Project: PROP - Parkside Neighborhood Center
& Affordable Housing
77 - 85 Grant Street

Addendum #5

**The Parkside Neighborhood Center
and Affordable Housing
Mellen & Grant Streets,
Portland, Maine 04101**

May 3,2004

S6.0

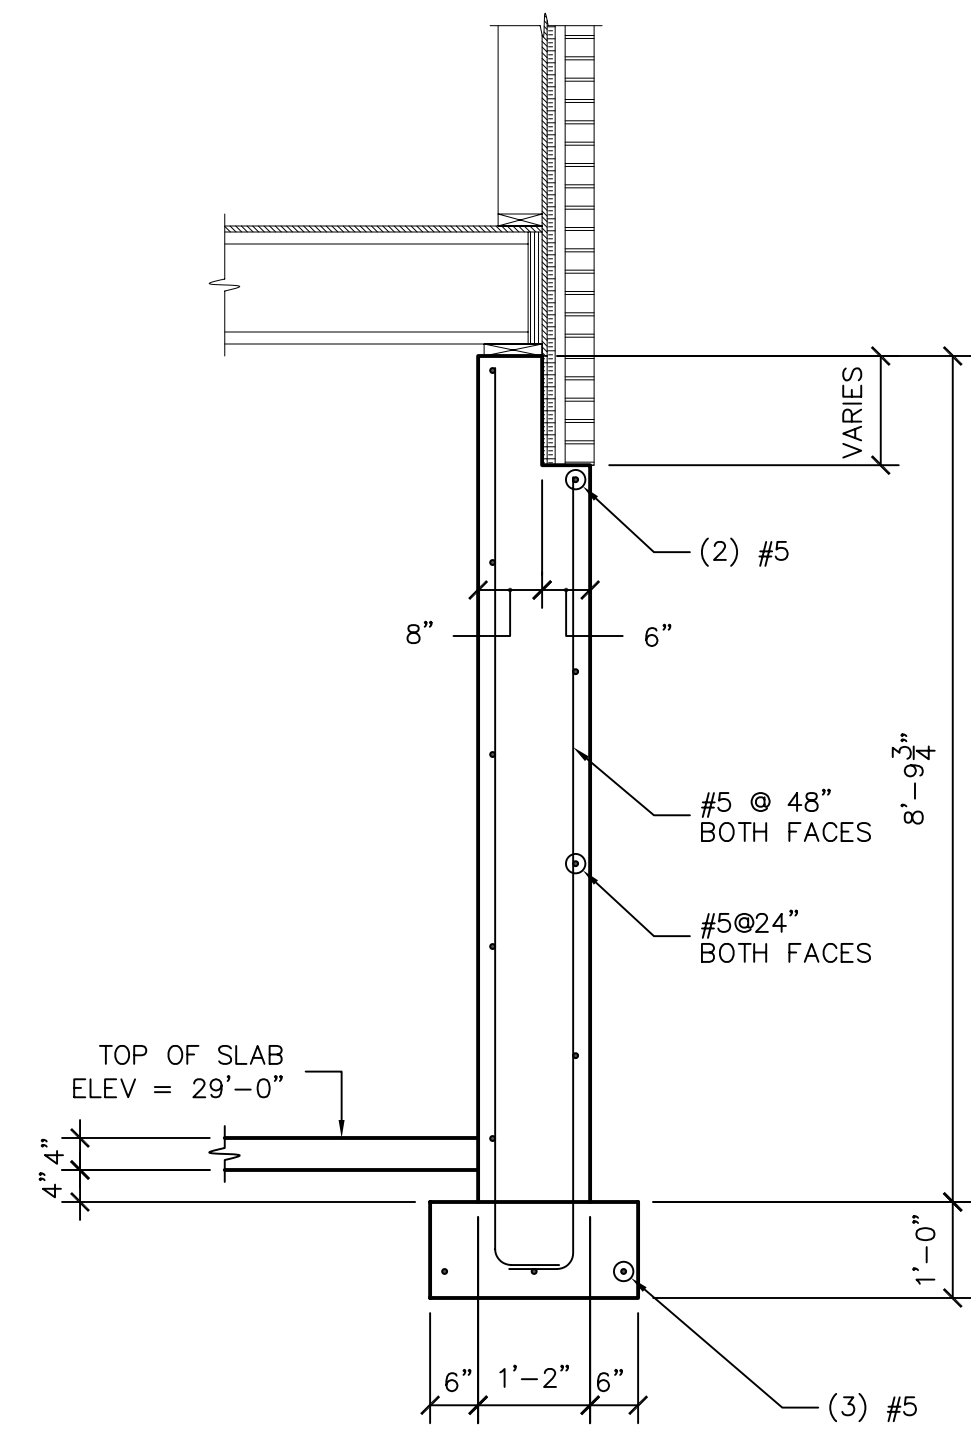
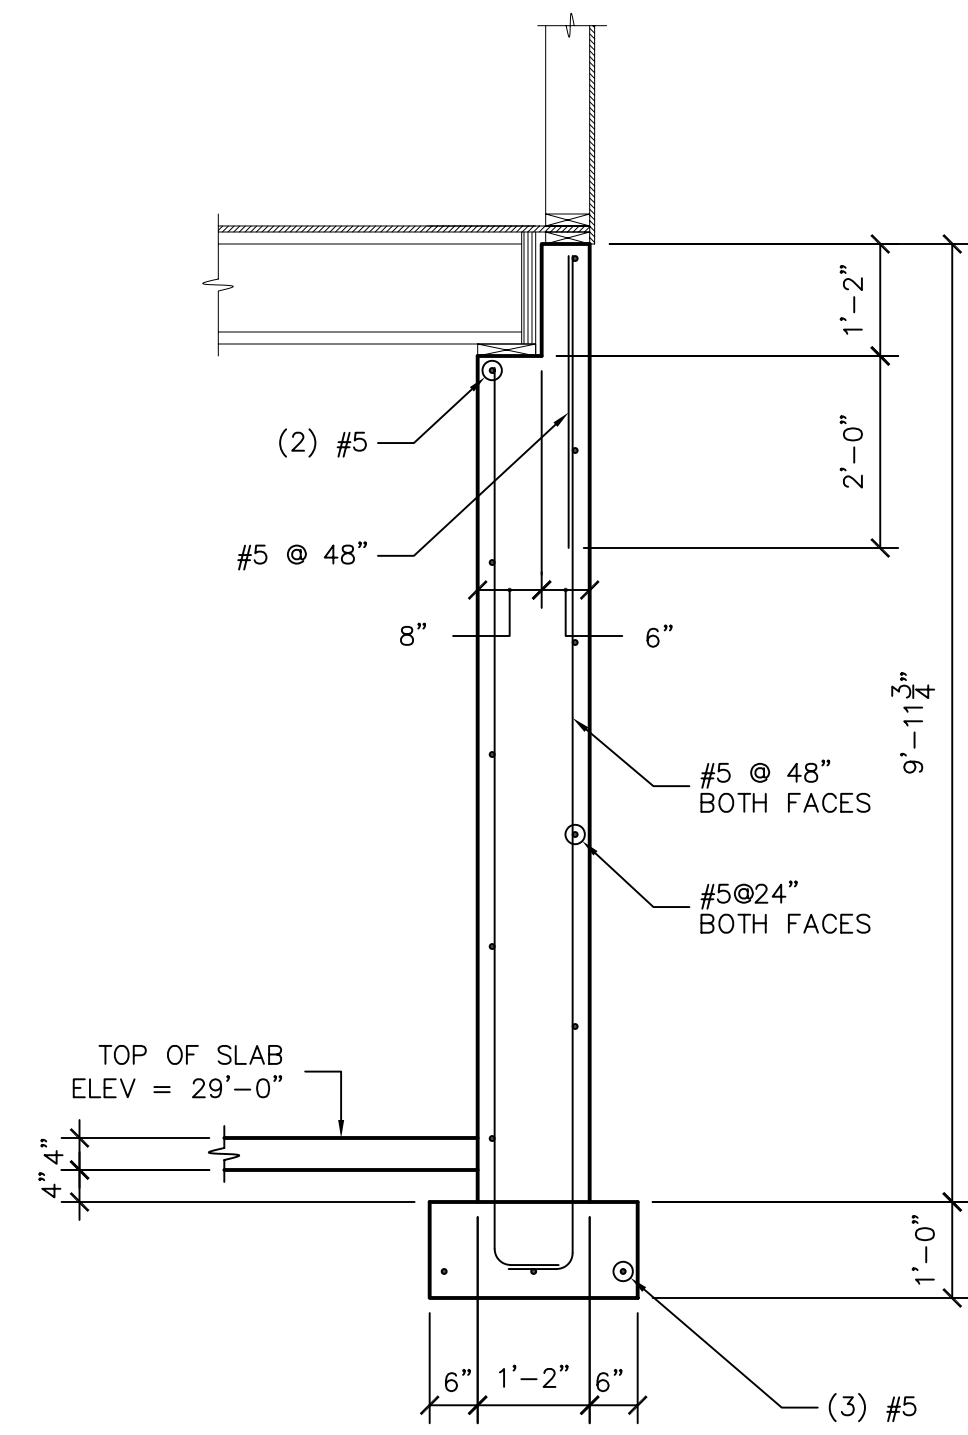
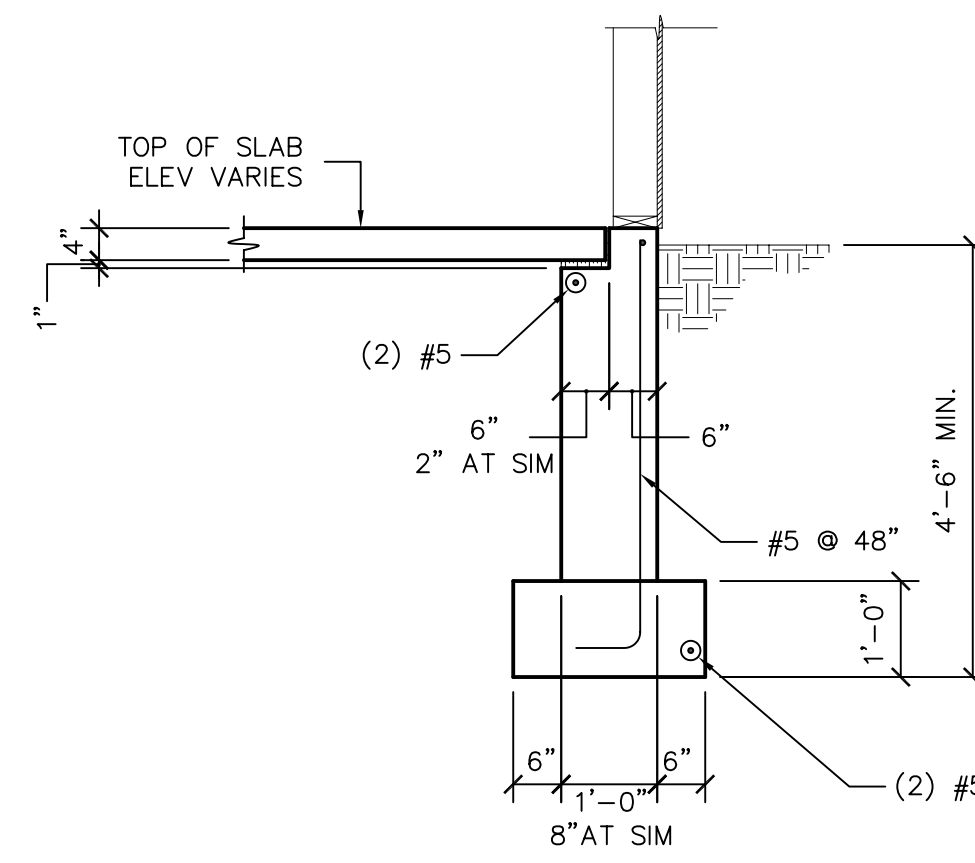
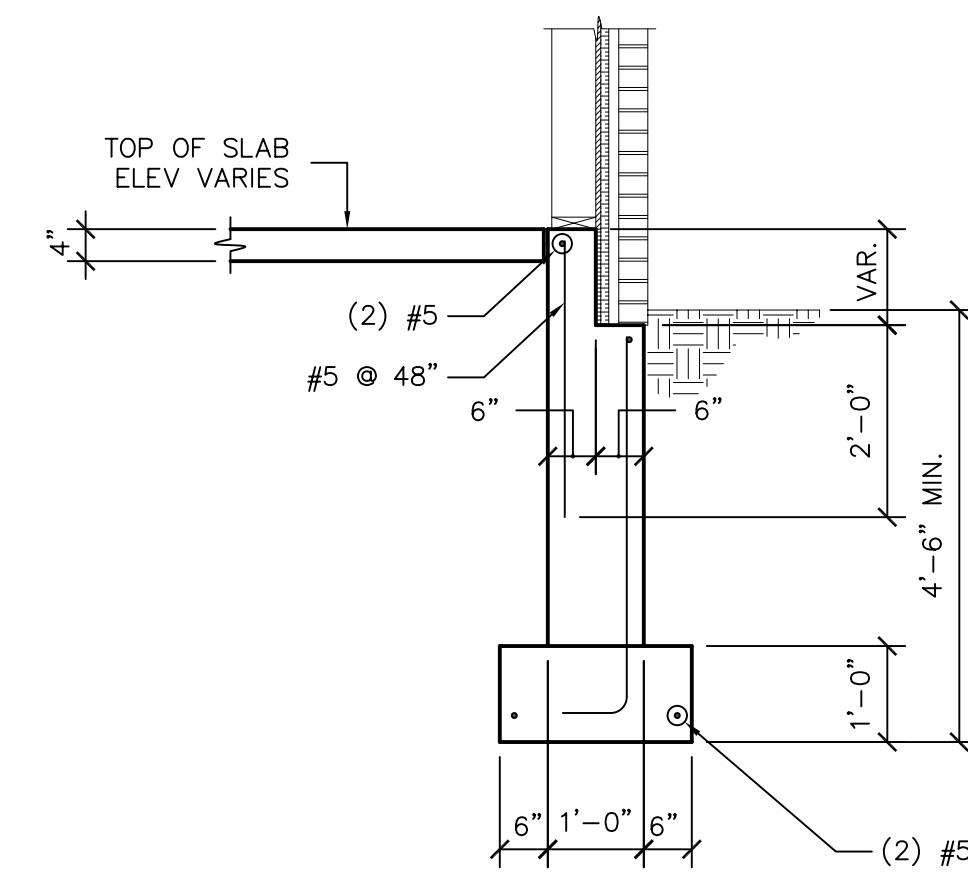
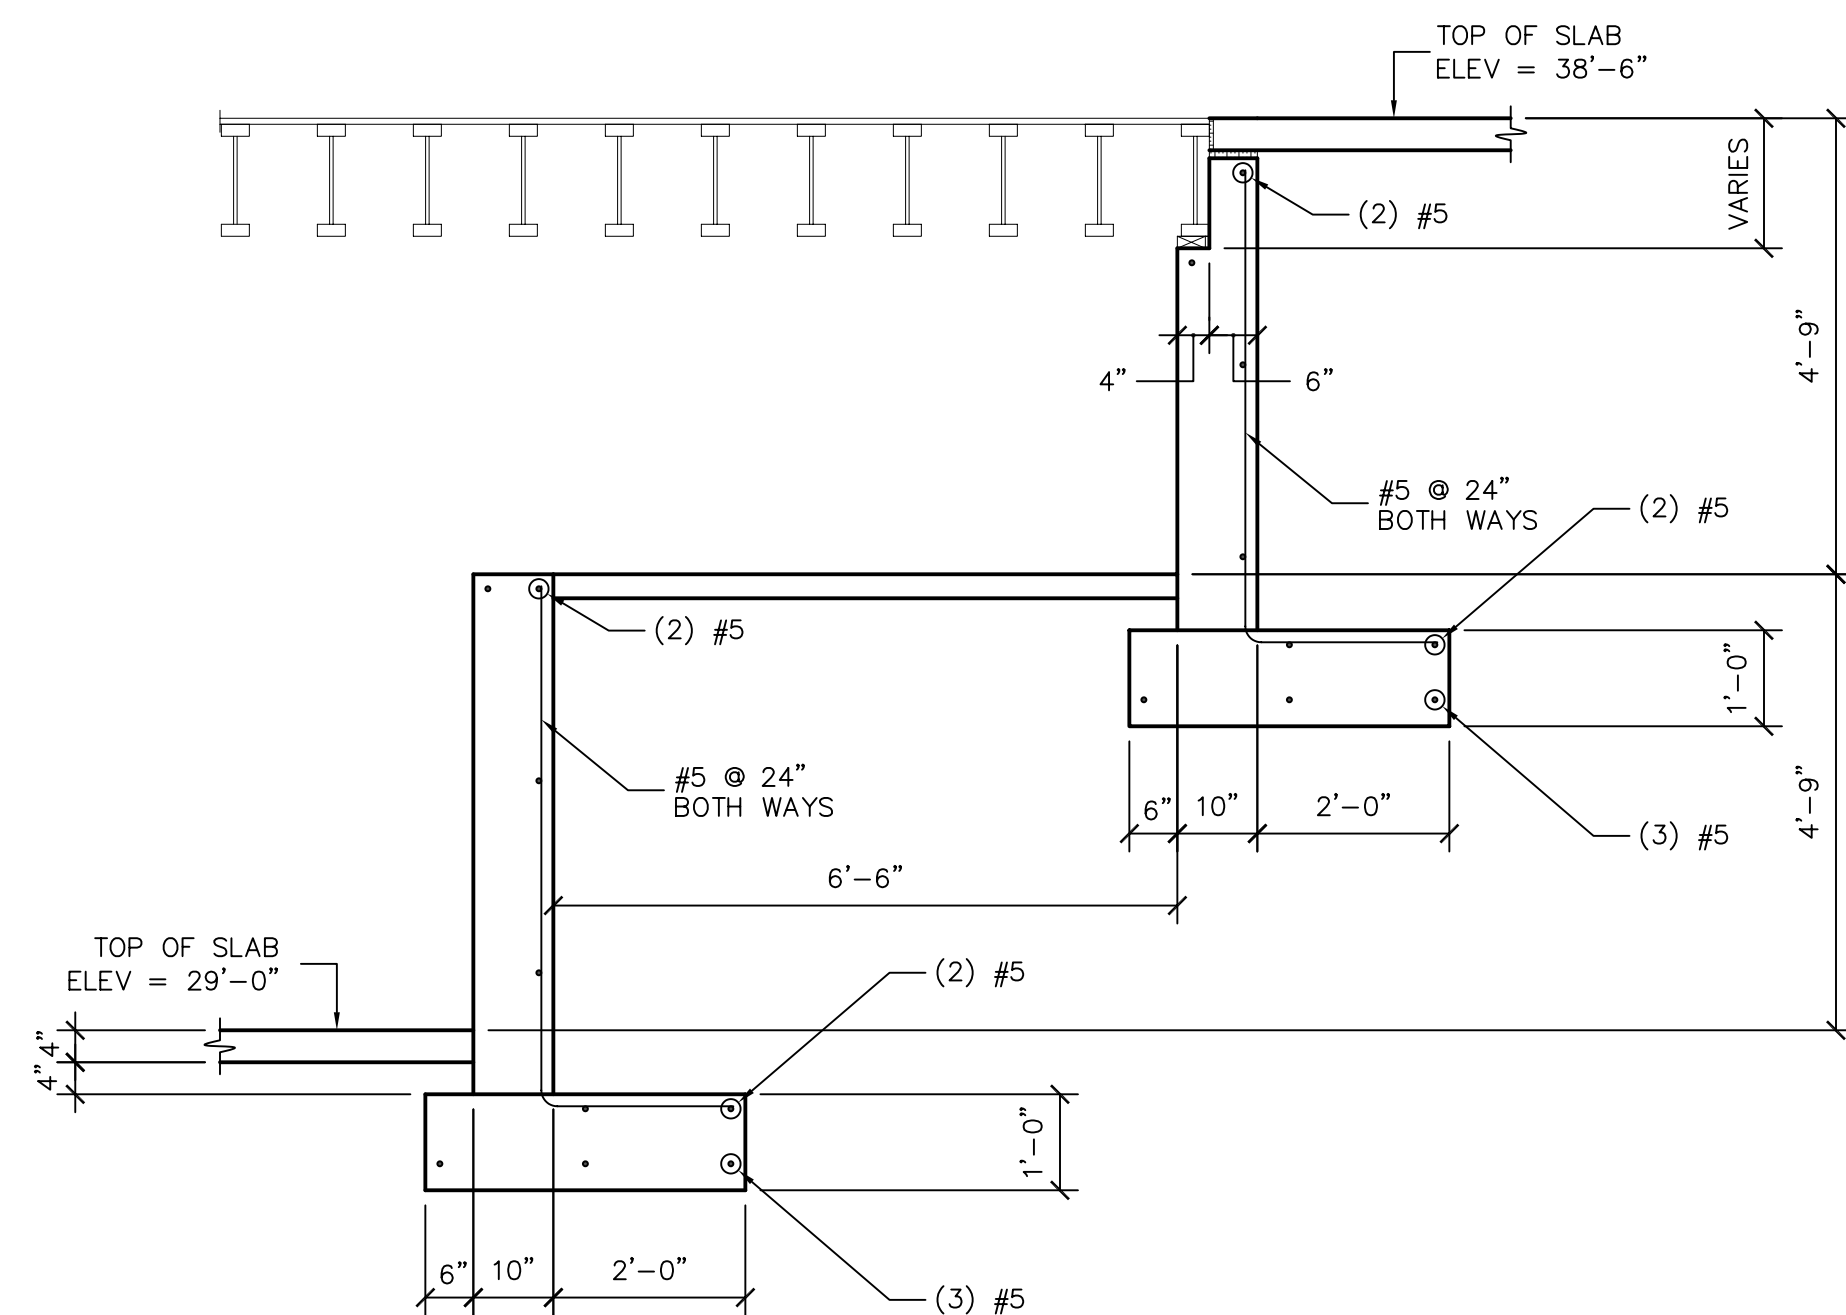
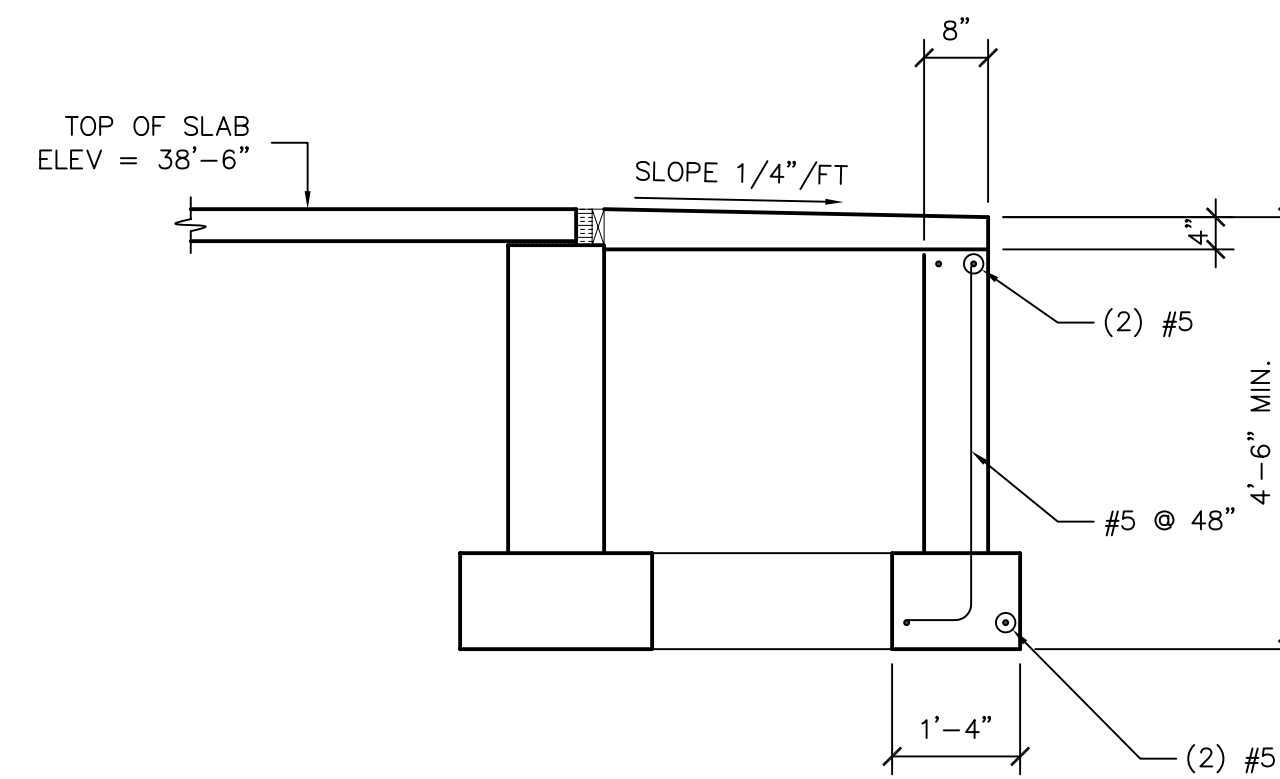
4-49	A S1.0	1	DELETE chimney footing 'F 1'. Chimney is deleted and replaced with metal stud and shaftwall per above items.
4-50	A S3.0	1	ADD section designation 6/S7.0-sim west of north porch. 'Sim' designates no brick in section.
4-51	A S4.0	1	REVISE dimension shown at north east corner from 7'-6" 1/2" to 7'-11 1/2".
4-52	AS5.0	1	REVISE dimension shown at north east corner from 7'-6" 1/2" to 7'-11 1/2". ADD note 'See 4/A5.1 Bldg A for porch roof framing'.
4-53	B S1.0	1	DELETE chimney footing 'F 1'. Chimney is deleted and replaced with metal stud and shaftwall per above items. REVISE south entrance area as shown on SK9.
4-54	A/B S6.0	1	ADD note 'See Sk7 for stringer sizes.
